## St James School

### Comments on Esso response to points raised in Alan Baxter report

1908/160/SK005

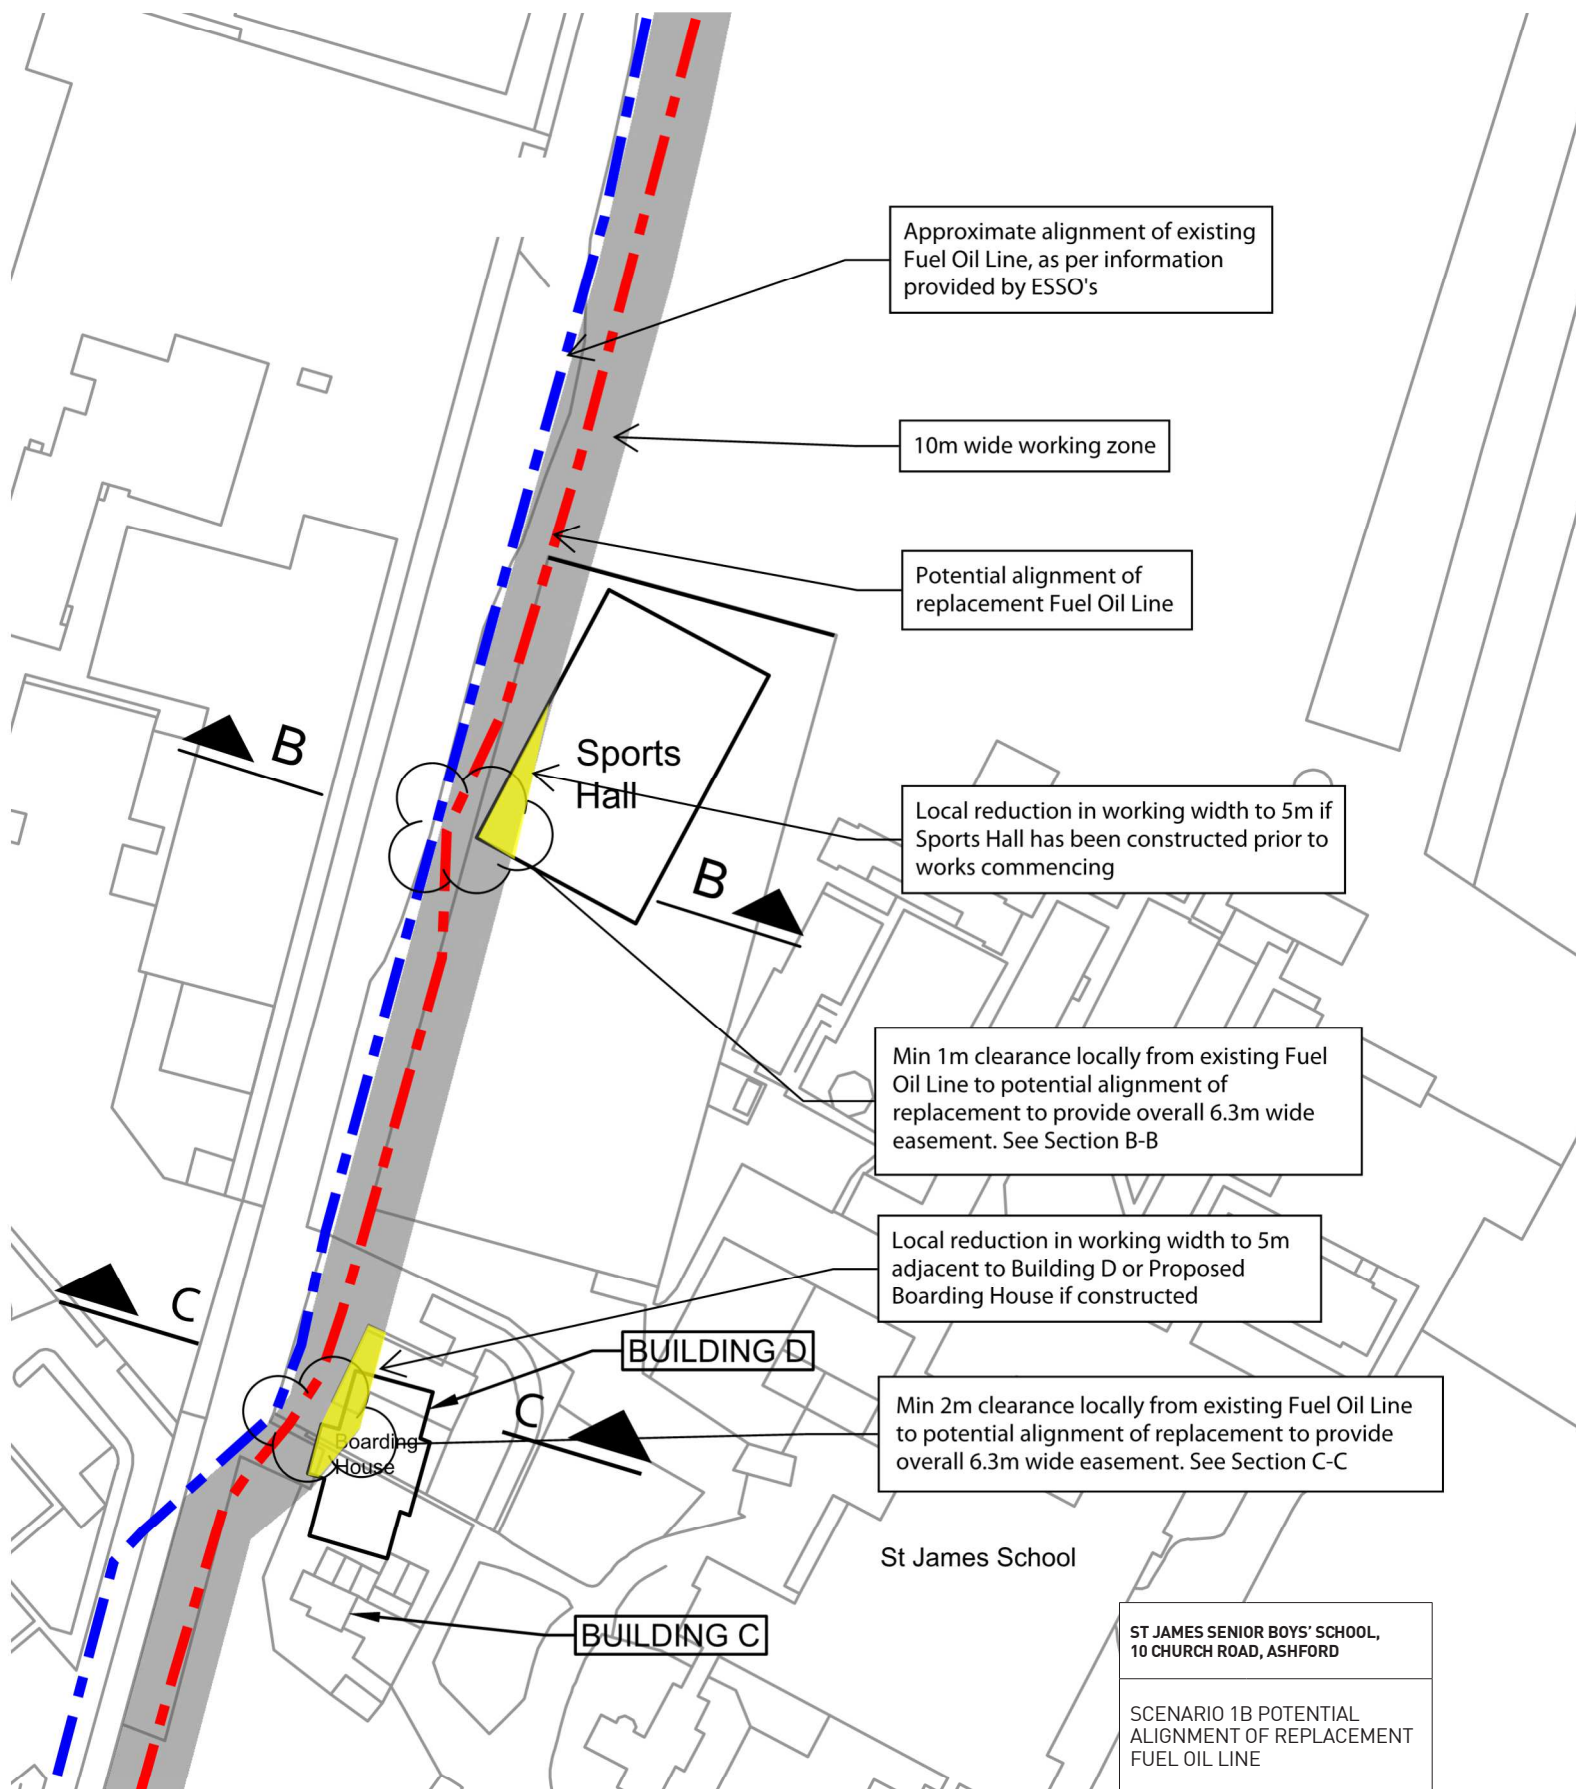
- Whilst Esso acknowledge that high water levels are a concern for the project (although there was no reference to this in SLT's technical note), it is not correct for them to conclude that this has little bearing on route selection.
- Esso have not addressed our comments in paragraphs 4.3.4 and 5.0 that as ground levels along the western boundary of the school are around 1 metre higher than along Esso's preferred route along the eastern playing fields, construction along this western boundary would be above the recorded water table as illustrated on our sketches SK 06 and 07 whilst construction would be below the recorded water table along Esso's route as illustrated on our sketch SK 03. This will add significant cost and complexity to their preferred option compared to Option 1B.
